**From:** Martyn White <Martyn.White@arun.gov.uk> **On Behalf Of** Conservation Officer  
**Sent:** 21 May 2025 16:58  
**To:** Planning.Responses <Planning.Responses@arun.gov.uk>  
**Subject:** CM/12/25/PL

**CM/12/25/PL**

*Rigates Climping Street Climping BN17 5RQ*

*Demolition existing buildings and erection of 1 No. self / custom build dwelling and garage with associated landscaping. This application may affect the setting of a listed building, is in CIL zone 5 and is CIL liable as a new dwelling.*

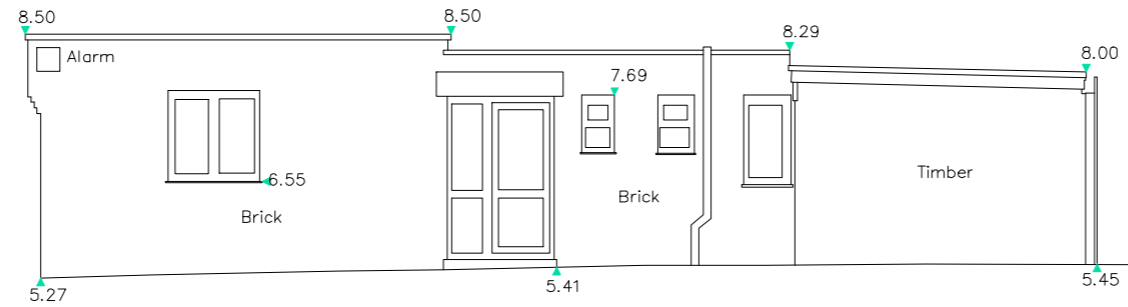
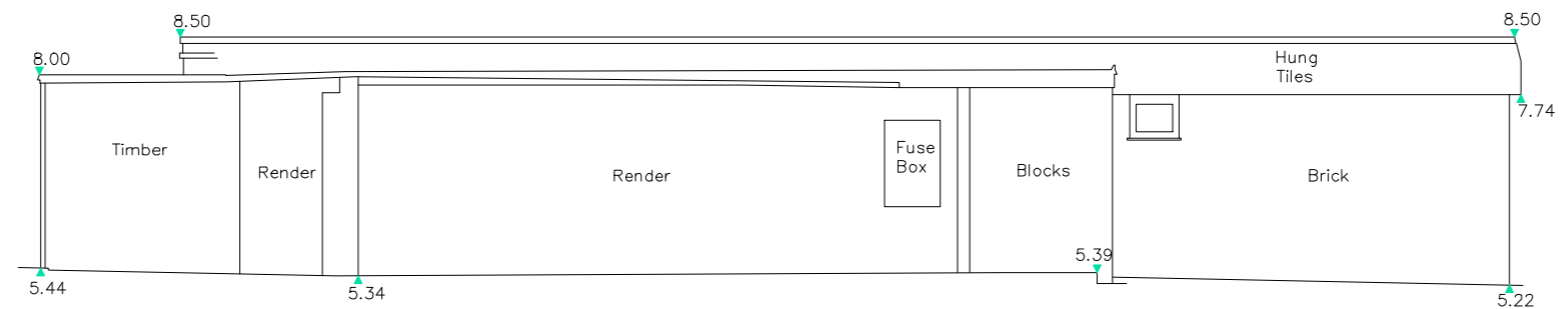
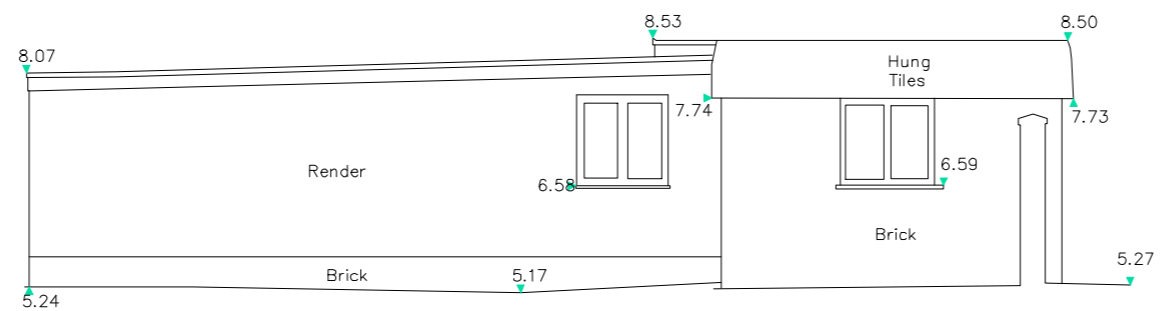
Whilst the concept of redevelopment and the location do not appear to cause issues from a built heritage perspective, this cannot be the case for the design and appearance of the dwelling itself. The lane has a rural character with traditional properties constructed from vernacular materials, each with a simple appearance. We are told in the Heritage statement that the dwelling will reflect the local vernacular, and the finish will be to a high standard. The statement identifies that this will be achieved through the use of materials that mirror the characteristics of rural development within the wider vicinity of the site. However, I believe that as drawn, the overall design is not truly reflective of the locality. For instance, the materials include brick, flint, clay tile hanging with decoration, roof tiles and horizontal boarding. The result is an overly complex design.

It is not clear why a simple, traditional appearance has not been selected. Especially as there are some good examples in the parish including 1 & 2 Rose Cottages/Black Horse Cottage, the aforementioned listed buildings, or The Black Horse public house. These and many others, have a simple elevation with a limited materials pallet, and are much more 'of the vernacular'.

The location of the proposed house and the presence of screening and existing development will mean that the proposed development would result in no harm to the setting of the designated and non-designated heritage assets, and therefore not harm their significance. However, the design and appearance of the new house is not fully reflective of the character of the historic hamlet and requires improvement/revision.
